WEST SUSSEX COUNTY COUNCIL CONSULTATION

TO:	Arun District Council FAO: Hannah Kersley
FROM:	WSCC Highways - Public Rights of Way
DATE:	6 October 2026
LOCATION:	Phase 6a Hampton Park, Littlehampton
SUBJECT:	LU/249/25/RES Approval of reserved matters following LU/47/11/ (amended by LU/182/15) comprising 288 No residential dwellings, the formation SUDs features, children's play space, landscaping, car parking, roads, landscaping and public access to the northern extent of the Black Ditch Open Space. Substitute drawing pack plans and additional plans received.
DATE OF SITE VISIT:	n/a
RELEVANT PUBLIC RIGHTS OF WAY NUMBER(S):	Footpath 3096
RECOMMENDATION:	Objection
S106 CONTRIBUTION TOTAL:

scheme: Hampton Park Littlehampton
client: Persimmon Thames Valley
drawing: POS North Black Ditch
date: November 2025
scale: 1:200@A1
drawing no: PERTV24807 19 - Sheet 2 of 16
drawn: JO checked: RH

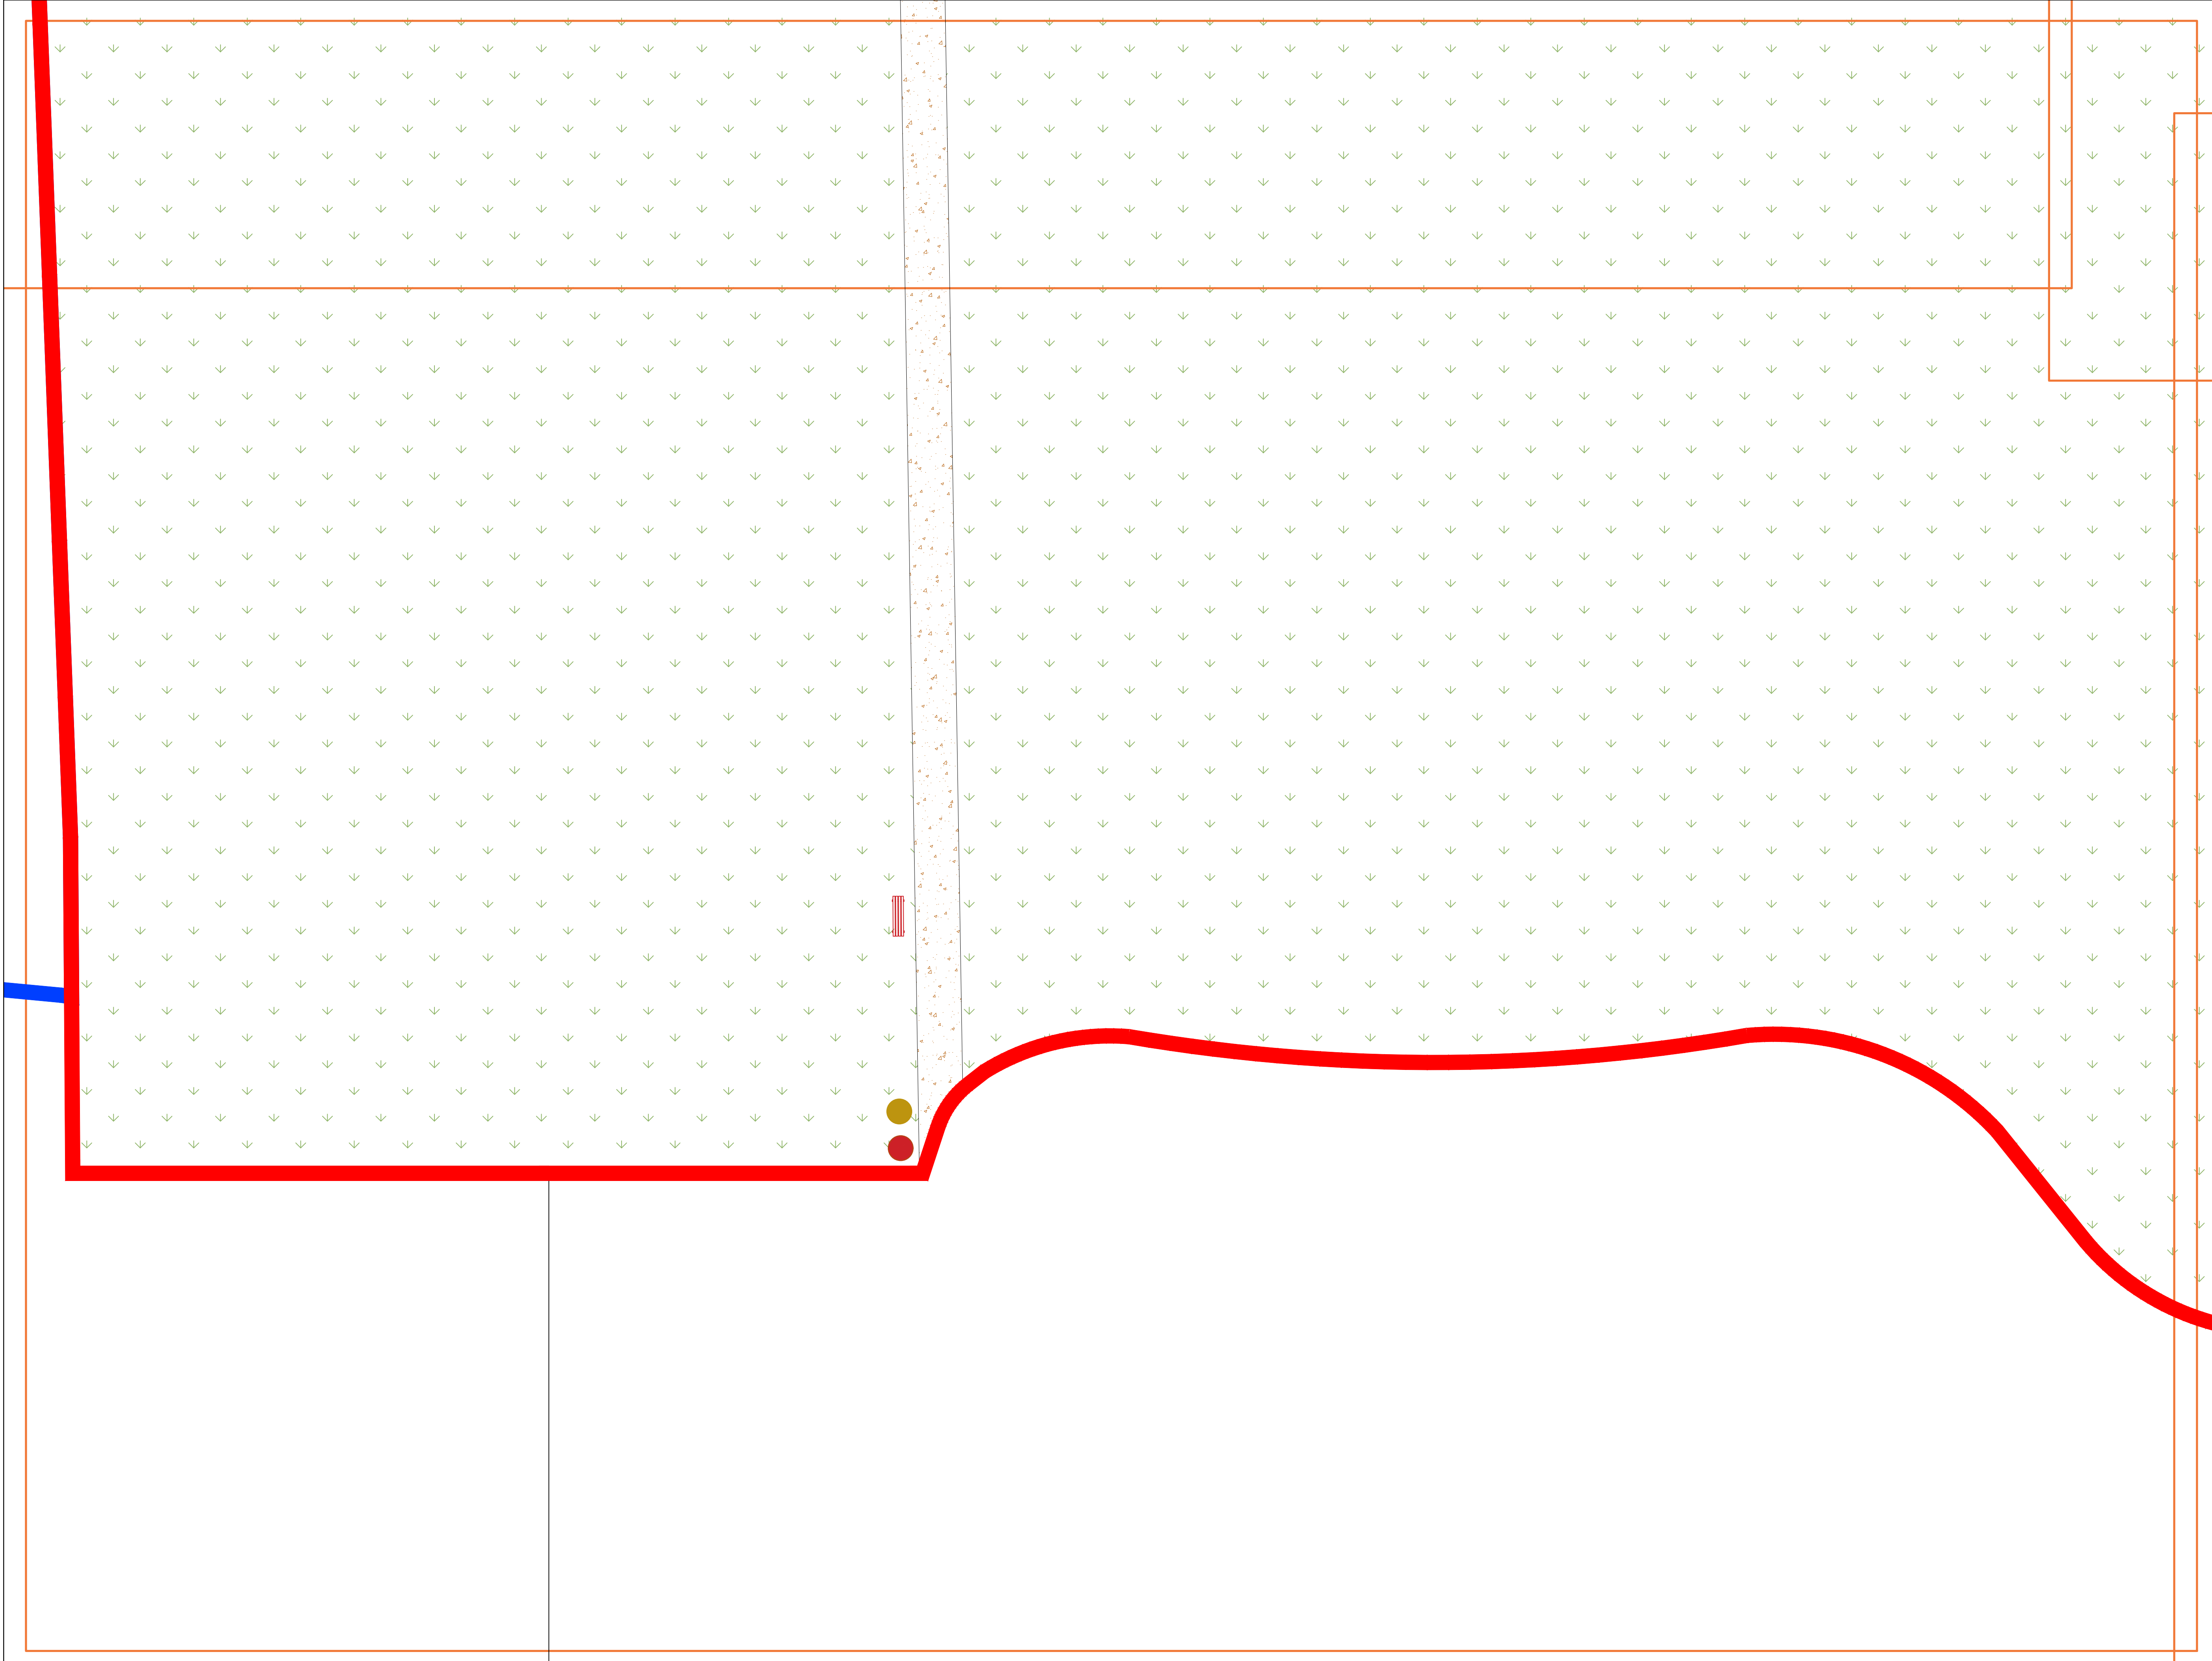
The new application documents show the developer proposes to surface Footpath 3096 with a self-binding compacted gravel which forms the basis of my objection. As per my response dated 16th February 2026, the surface should be made up to the rural footpath specification, shown below, which we, as Highways authority, are able to maintain.

9. Footpath to be constructed with 1 in 40 (2.5%) camber (centre high) or crossfall as specified by WSCC PROW Officer to help shed water from surface.
10. Limestone Dust to be rolled a minimum four times. Stabilisation to be encouraged by surface dampening whilst rolling.

OPTION A	
<i>Sub-base</i>	
Clean material suitable for use as a sub-base with grading approximately 75mm to dust (e.g. crushed chalk or similar quarried stone)	175-225
<i>Surface / Top Dressing</i>	
Type 1 Limestone	100
Limestone Dust	25
